CITY OF PORTLAND BUILDING PERMIT

Job ID: 2012-03-3584-ALTCOMM

has permission to Add solar (PV) panels to building on 29' and 80' of walls in an awning type array provided that the person or persons, firm or corporation accepting this permit shall comply with all of the provisions of the Statues of Maine and of the Ordinances of the City of Portland regulating the construction, maintenance and use of the buildings and structures, and of the application on file in the department.

RE: ReVision Energy Solar Installation at Coastal Equipment
Address: 142 Presumpscot Street

142 Presumpscot Street Portland, Maine, 04097 207-221-6342	
ReVision Energy			
Solar Panel Awning Mount Detail			
System Perpendicular to Presumpscot St.			
DATE	DRAWN BY	PAGE	DWG#
4/26/2012	Geoff Sparrow	1 of 1	1
			Rev. 1

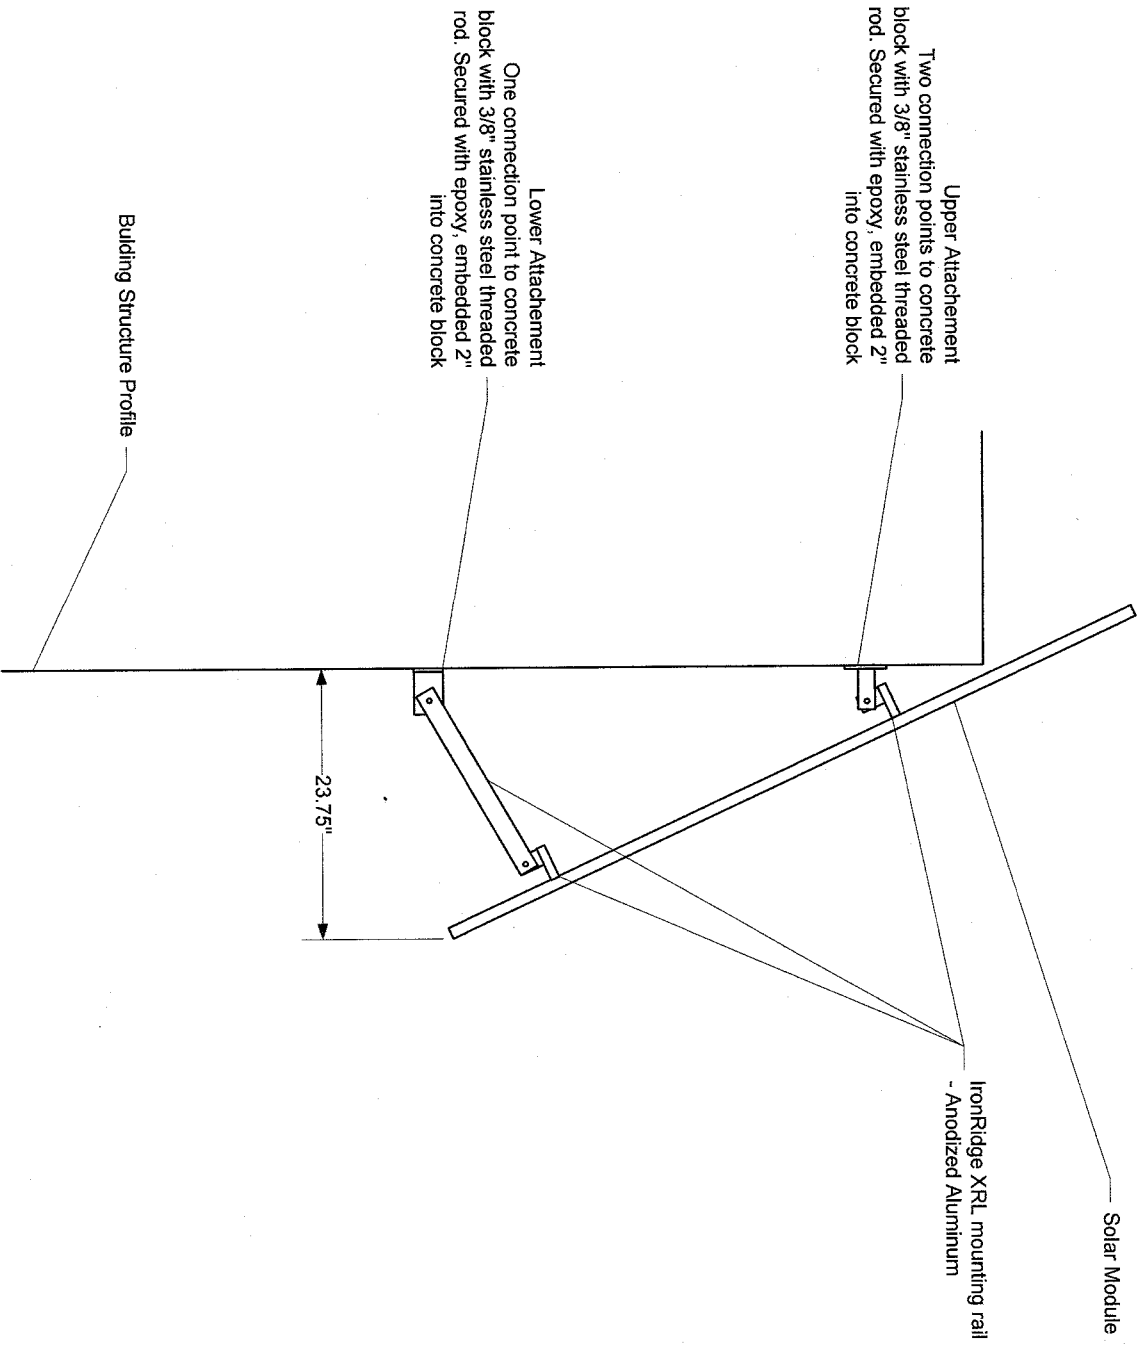
front setback 25' - non conformity
- front panels not extend more
than two lot.

Are you just making the pitch of the panels steeper on the front? We will need information that shows how far the panels extend off the front and the side.

The panels on the front will be steeper pitched to be within 24 inches of the building. The panels on the side will stick to their original plan - which is 3.6' off the building.

We're going to make the pitch of the panels steeper to keep the distance within two feet of the building. I'll make copies of the site plans and come in to pay the administrative authorization application. Let me know if there is anything else you will need at this time.
